**SCOTTISHPOWER RENEWABLES OFFSHORE WINDFARM DCO APPLICATIONS
REP. REF. 20023106 IN RESPECT OF EA1N PINS REF. EN010077
REP. REF. 20023105 IN RESPECT OF EA2 PINS REF. EN010078**

Please find below the Relevant Representations of Suffolk County Council in respect of the East Anglia One North and East Anglia Two offshore wind farm DCO applications.

TITLE
A1094/ B1069 WIDENING FOR ABNORMAL INDIVISIBLE LOAD

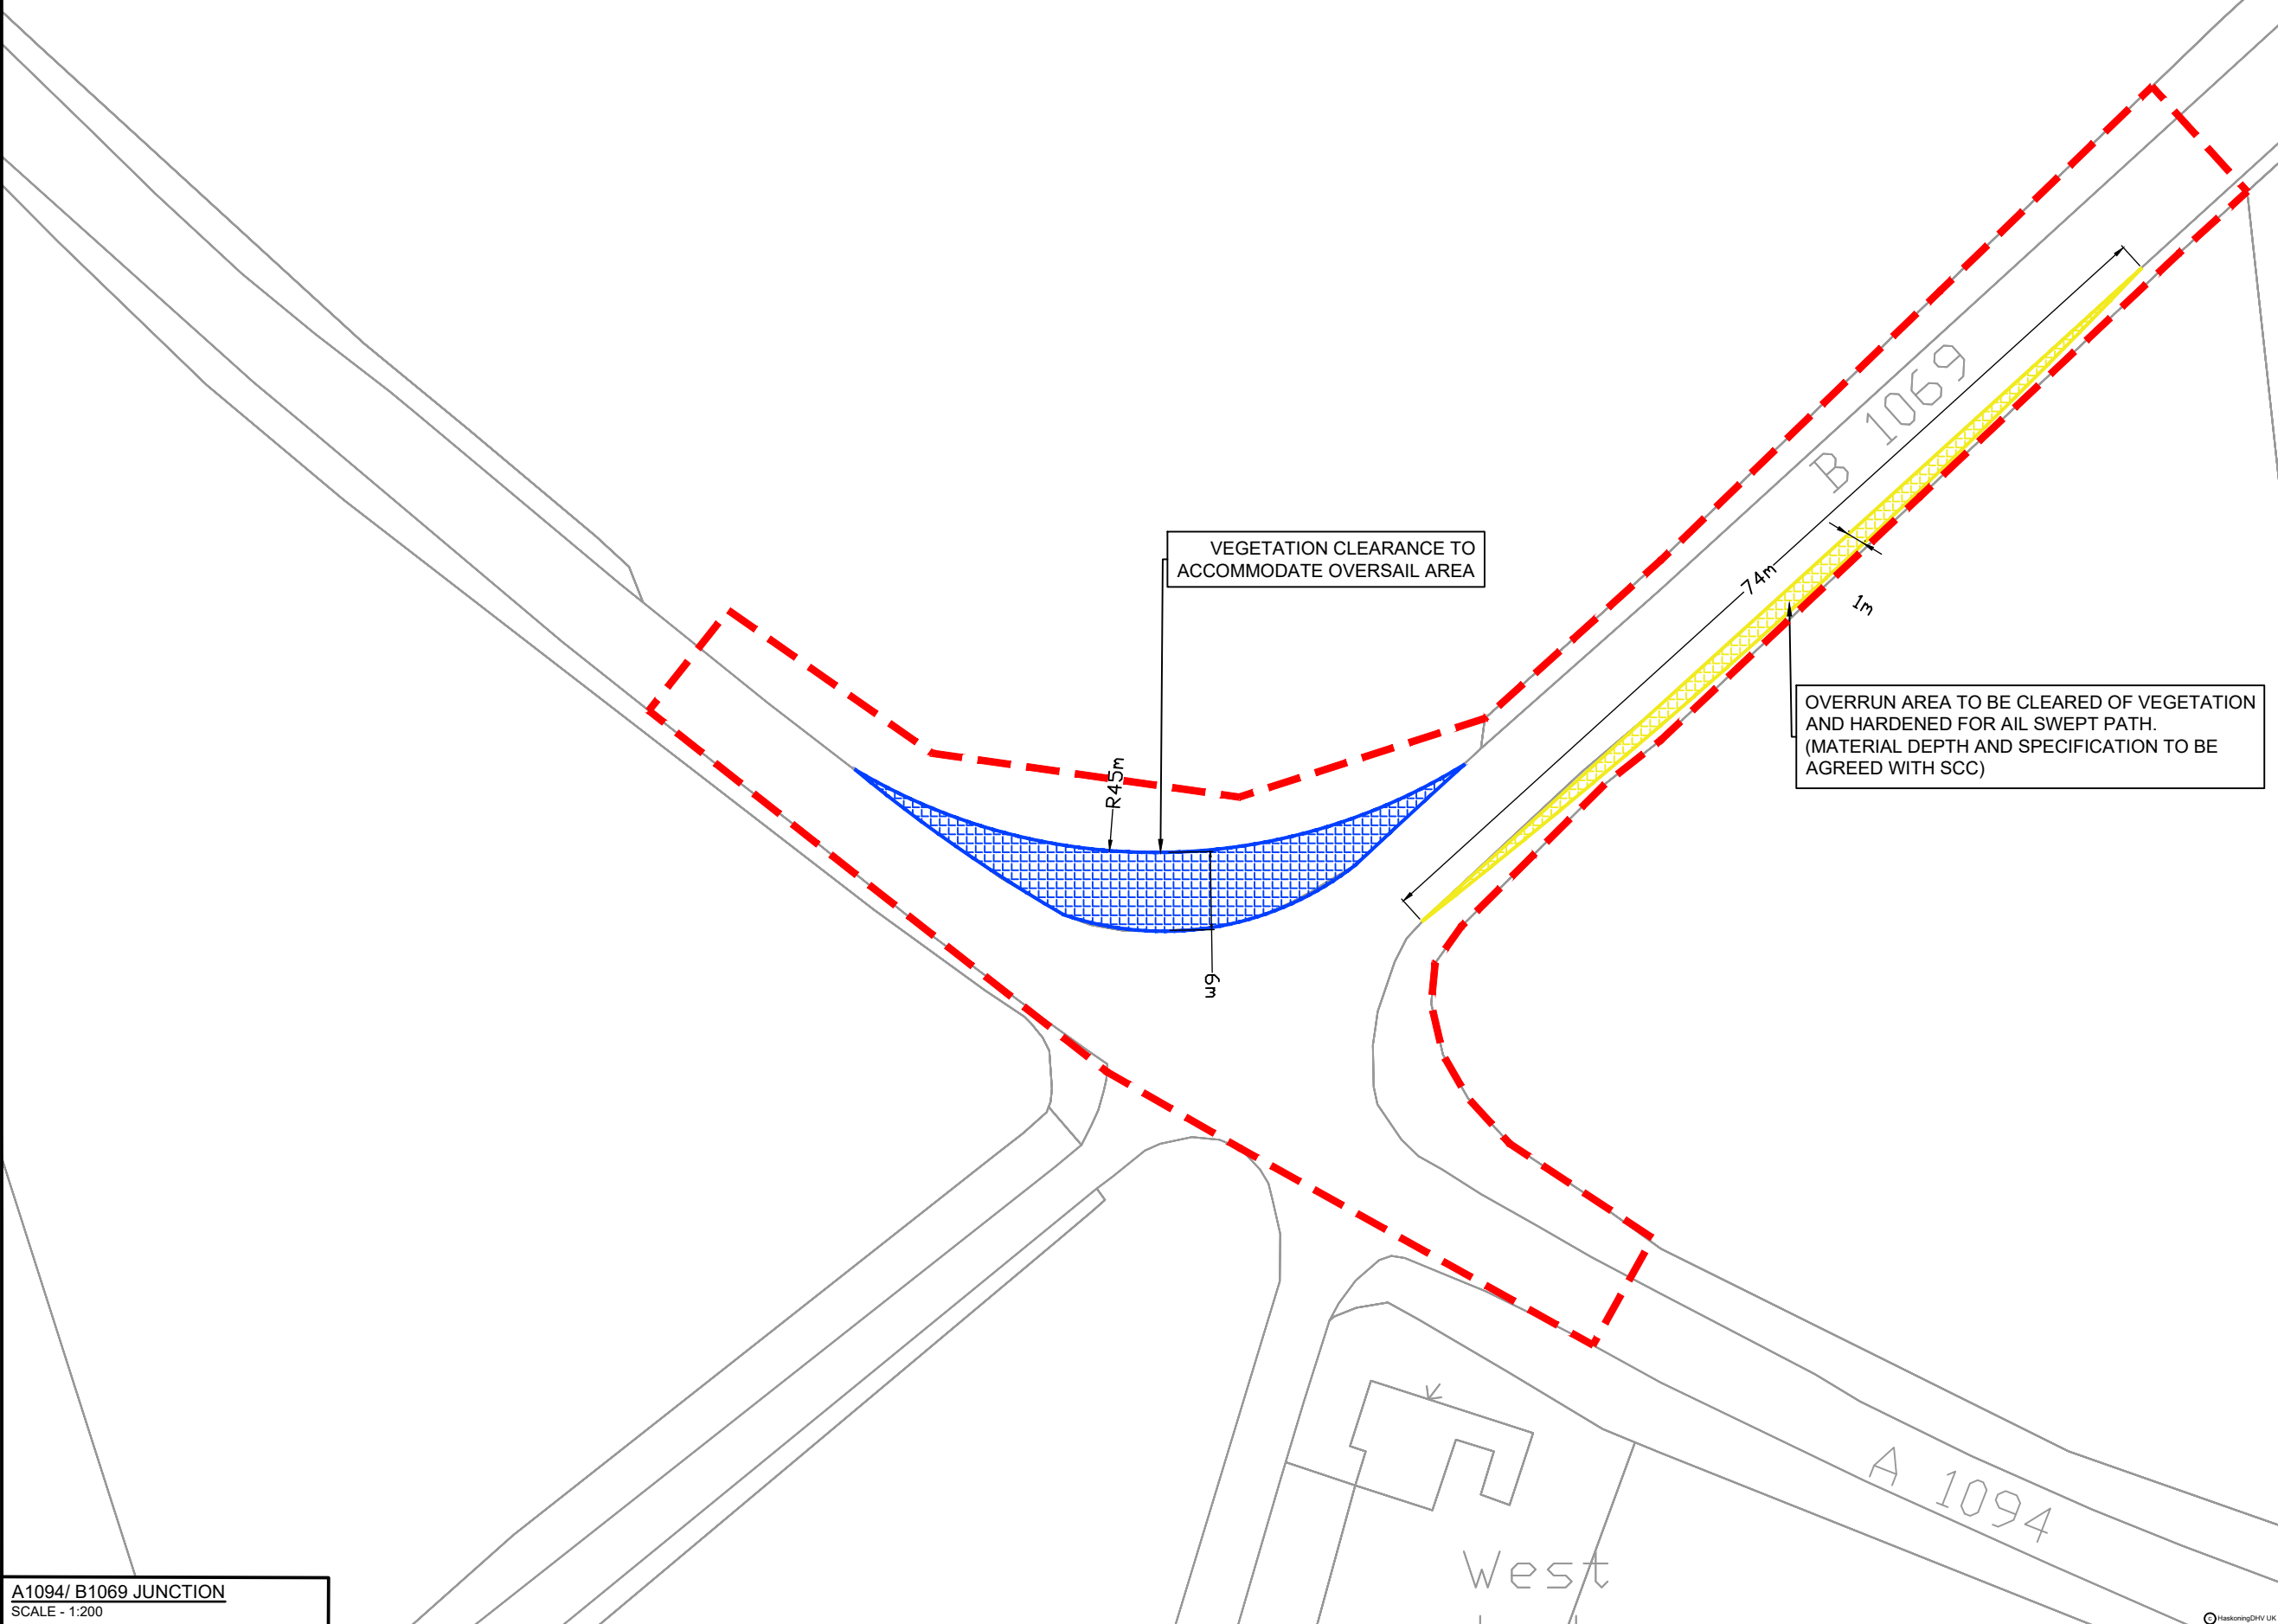
- Traffic and Transport - The Council considers that the proposals are inadequate in a number of ways including:
 - the provisions for abnormal loads are insufficient, particularly for the future as AIL access for maintenance and decommissioning are not assessed in either the ES or Transport Assessment (TA) beyond local widening of the B1069/A1094 junction;
